From: Andrew Wood
Sent: 27 November 2018 17:07
To: [REDACTED]
Cc: [REDACTED]
Subject: FW: A/106/18/PL - Somerset House, Angmering
Attachments: 0225_101D Location Plan.pdf; 0225_102C Pr Plans.pdf

From: Peter Davey [REDACTED]
Sent: 27 November 2018 15:28
To: Andrew Wood
Cc: 'Julie Cleasby'
Subject: RE: A/106/18/PL - Somerset House, Angmering

client	project	drawing	date	drawn	drawing no	revision
Julie Cleasby	Change of use at Somerset House, High Street Angmering, BN16 4AG	Location & Site / Block Plan	Mar 18	pd	0225 / 101	C
			scale	CAD file name:		
			1:200, 1:100, 1:1250 @ A3

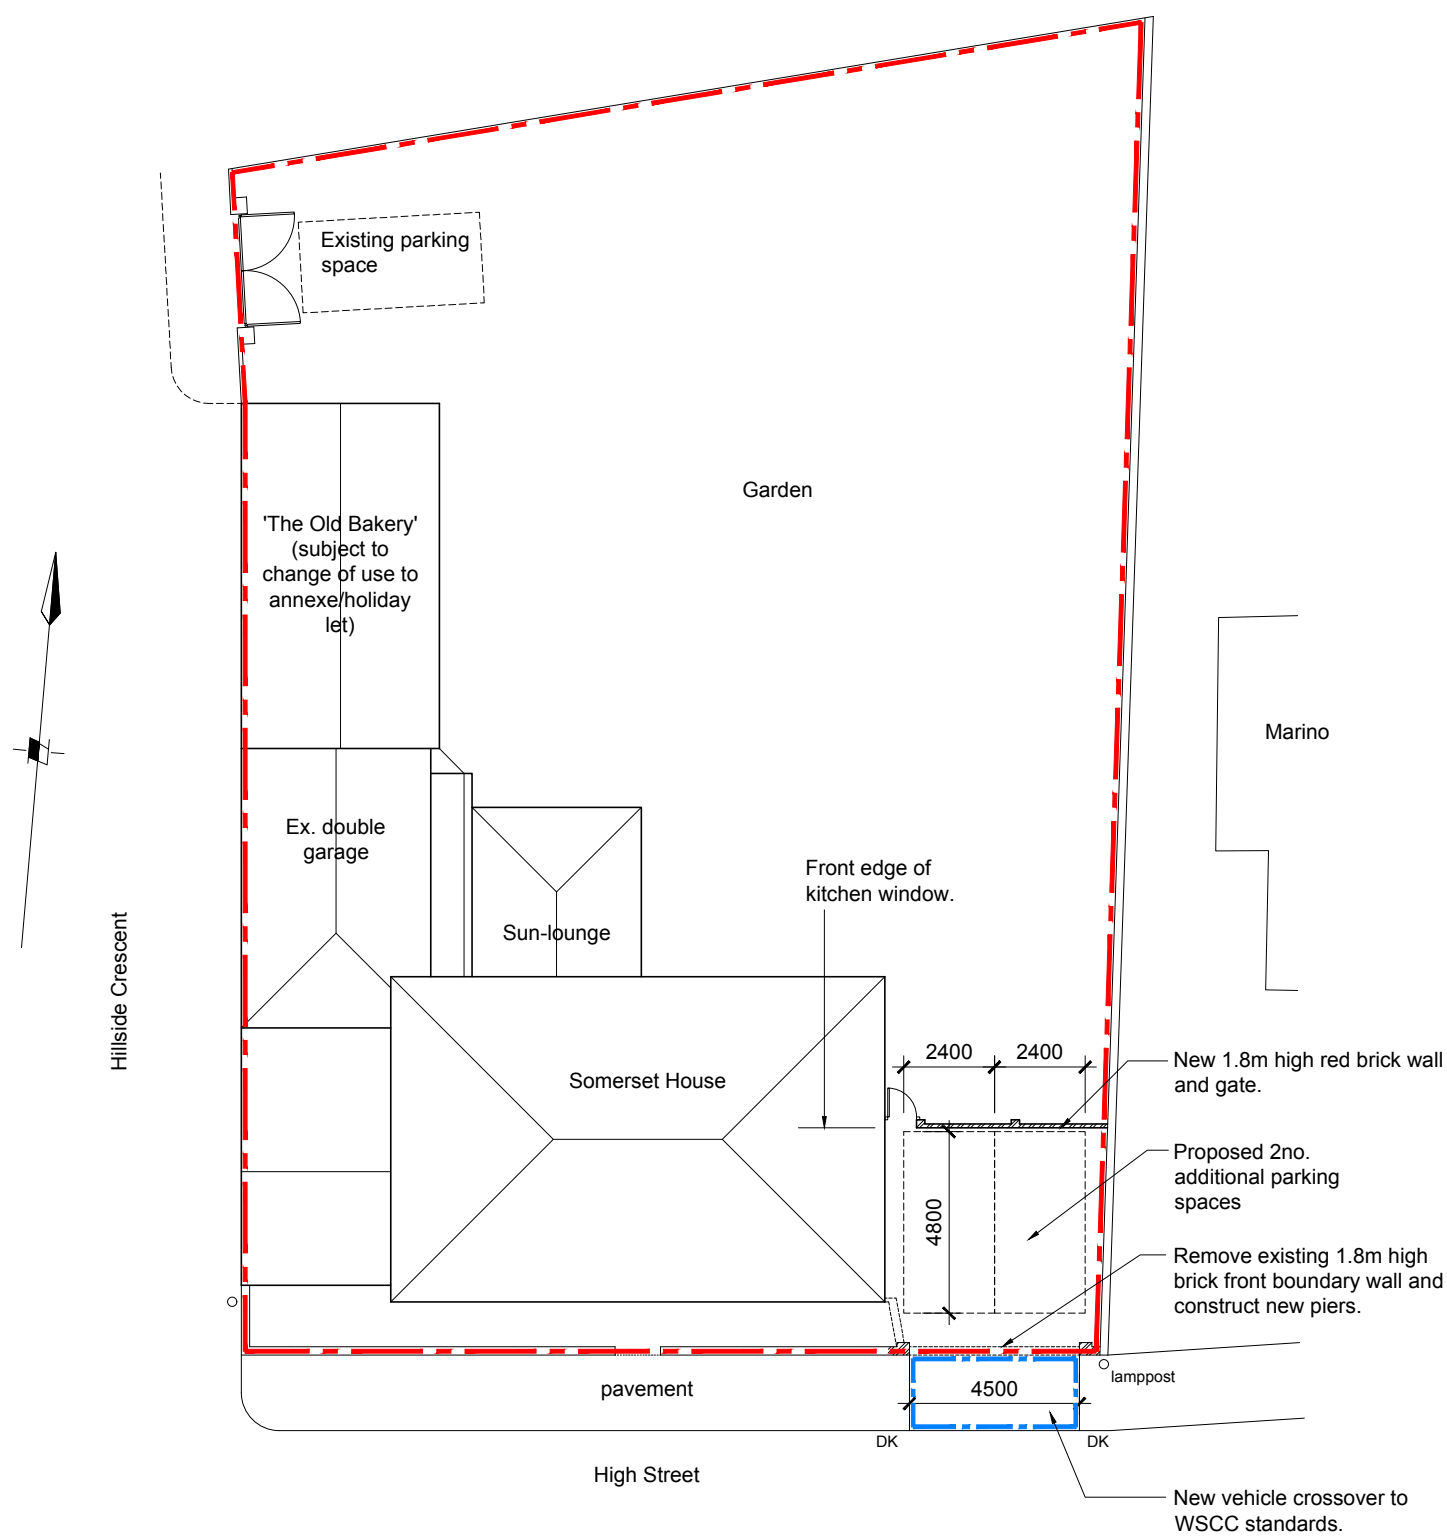
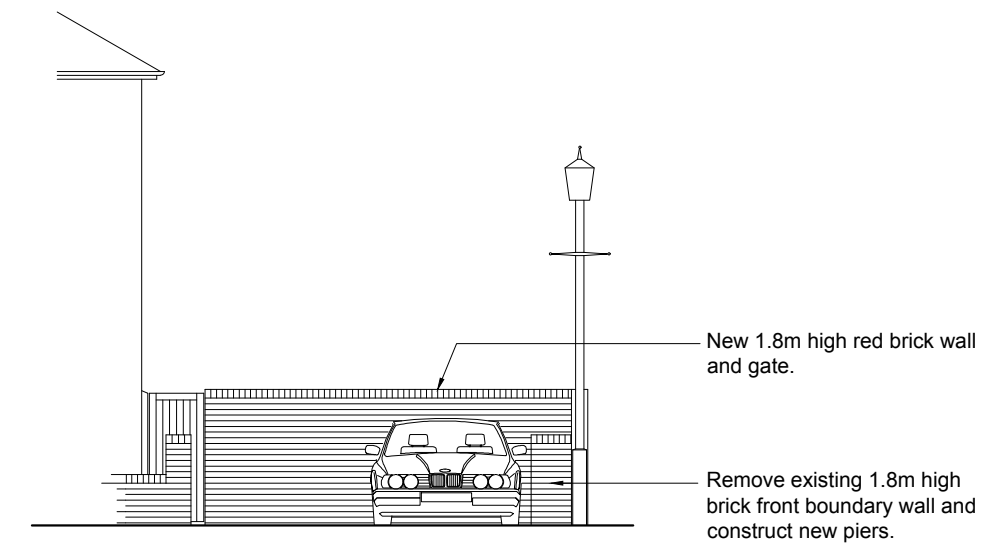
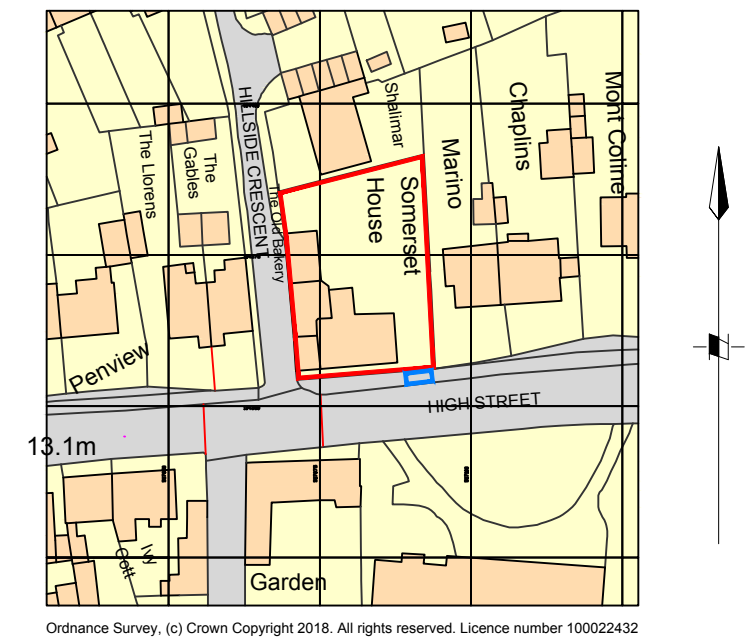
The parking demand for the dwelling and annex would be 4 spaces.
I would therefore advise the inclusion of a further car parking space to the rear of the property using the existing gate at the rear.
If this is not provided I will need to reconsult with highways or the conservation team if the gate/wall is altered.

Can you please provide updated plans removing the two parking spaces and wall alterations at the front, the timber front door and conservation style roof lights.

The demolition of the front wall and creation of two parking spaces at the front of the dwelling has attracted objections from both the Conservation Officer and the Conservation Area Advisory Committee. It is considered that this part of the scheme is contrary to policy in the Arun Local Plan and Angmering Neighbourhood Plan relating to Conservation Areas.

Can I request that you remove this element of the scheme. It might be possible add a further parking space at the rear of the property where a single existing parking space is shown on dwg.no. 0225/101 C

- * New cross-over and additional parking spaces off High Street omitted and wall left unchanged.
- * Single parking bay behind Annexe widened to create two spaces. No alterations to wall facing Hill Crescent.
- * Velux rooflights amended to Clement Conservation style rooflights.
- * Front door amended to timber.

Together with the existing double garage, this brings the total number of parking spaces available to four, which we understand meets Highways requirements.
